Your ref:  
Our ref: 22/00002/F  
Please ask for: Mrs Rebecca Bush  
Direct dial: 01553 616825  
Direct fax: 01553 616652  
E-mail: borough.planning@west-norfolk.gov.uk

Details: **Conversion of existing un-used cottage to 2x 2-bed holiday lets at Dovecote House Church Road Walpole St Peter Norfolk PE14 7NS**

I have received a planning application as detailed above but cannot process it until I receive some more information:

TITLE
Site and Location plans (Ex & Pr)

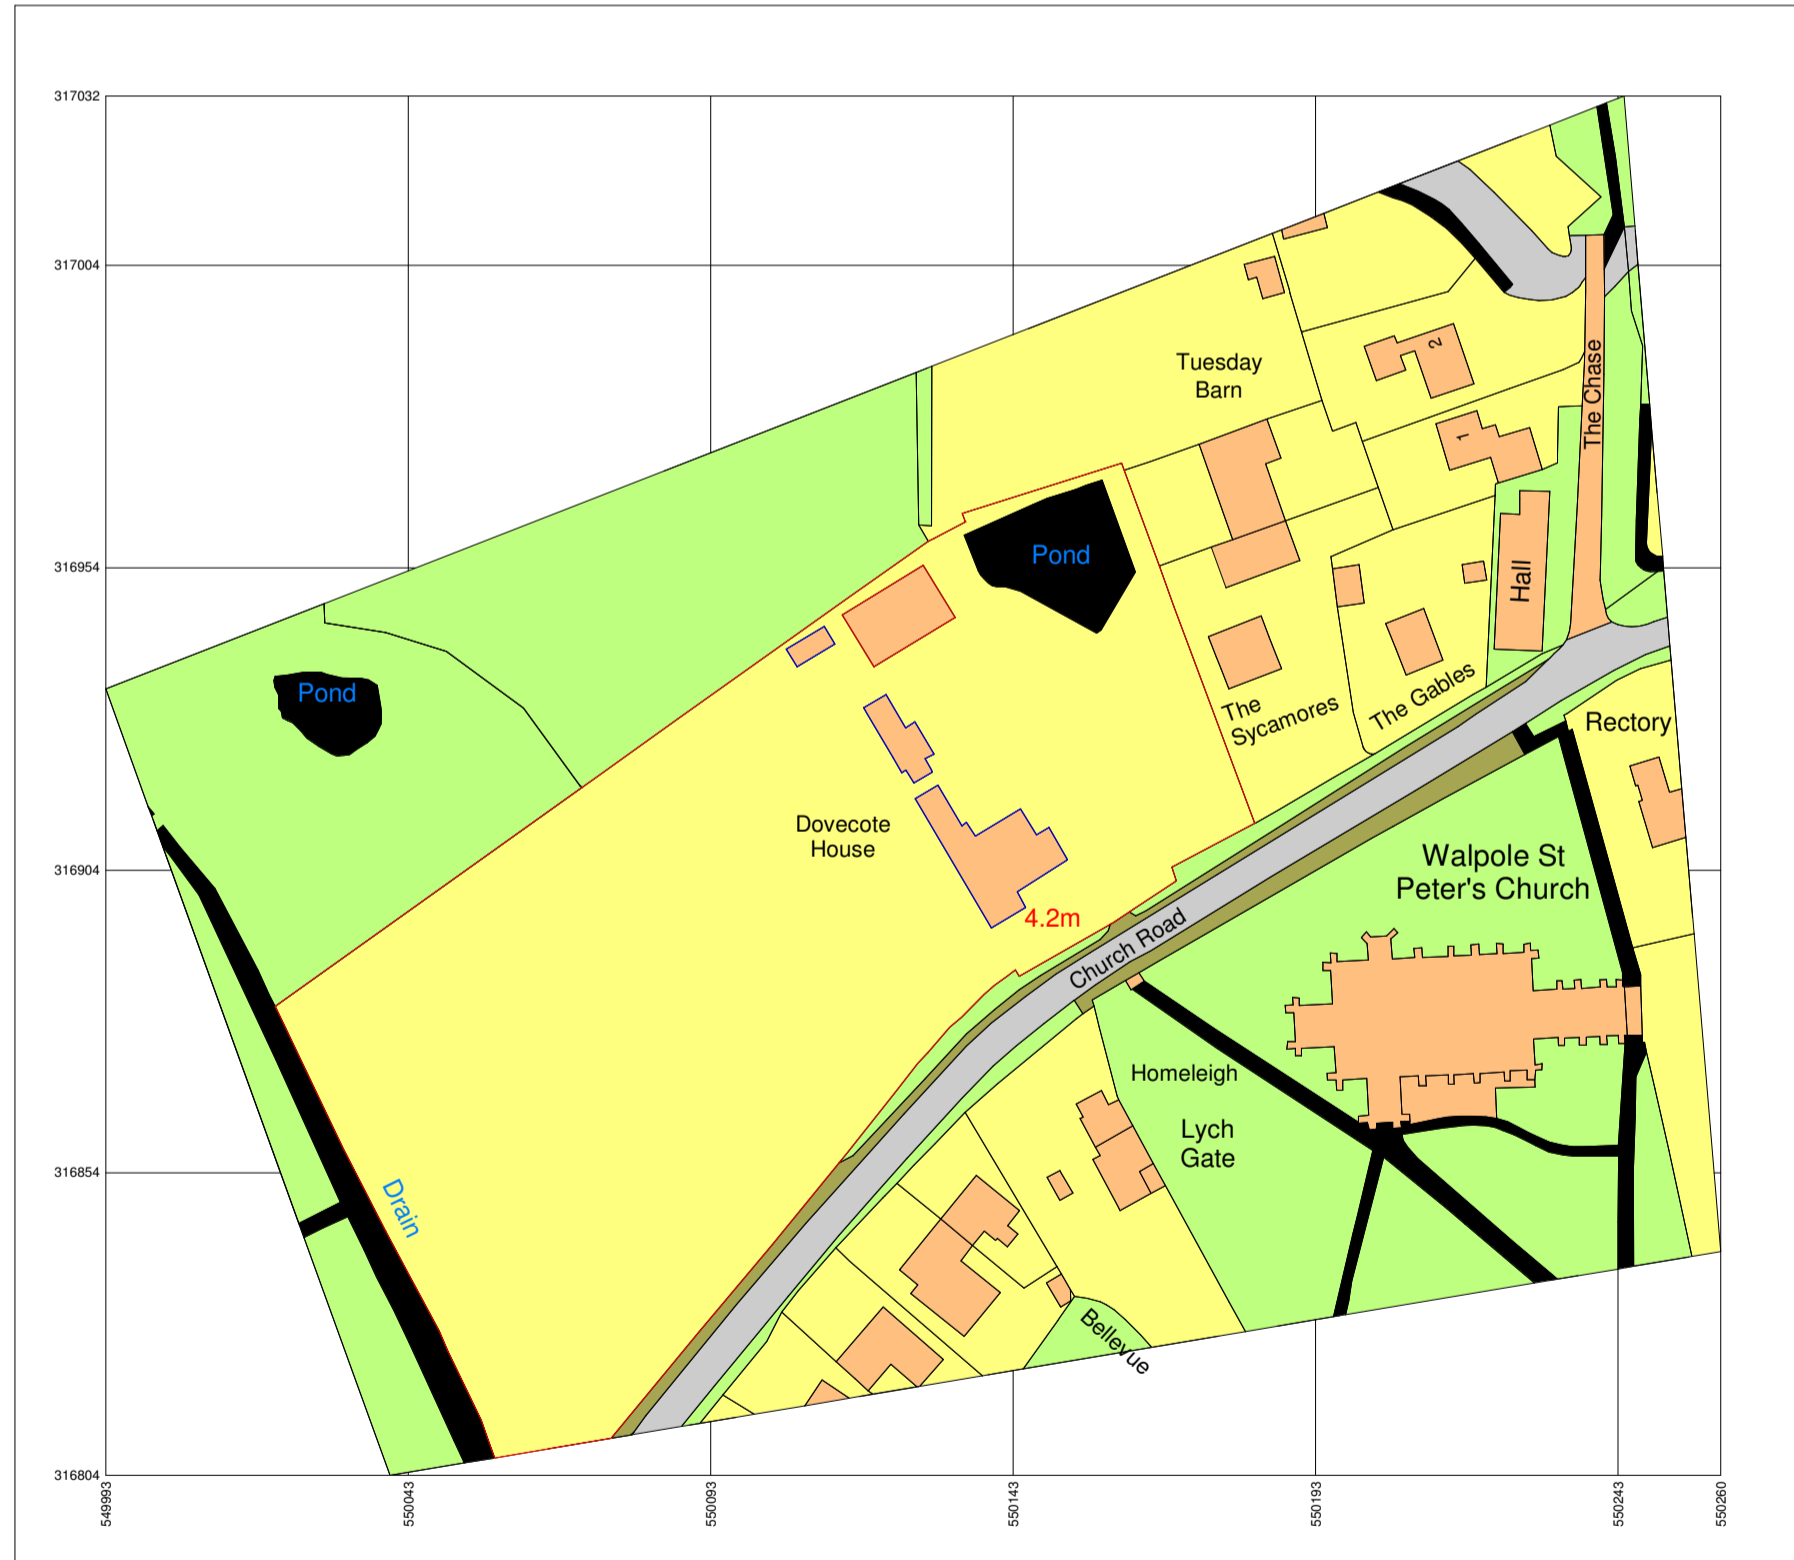
1. Will the holiday lets be using Dovecote Houses garden etc. We only ask as regards to the location plan you need to edge the new work in red and any other adjoining land owned by your clients edge in blue.
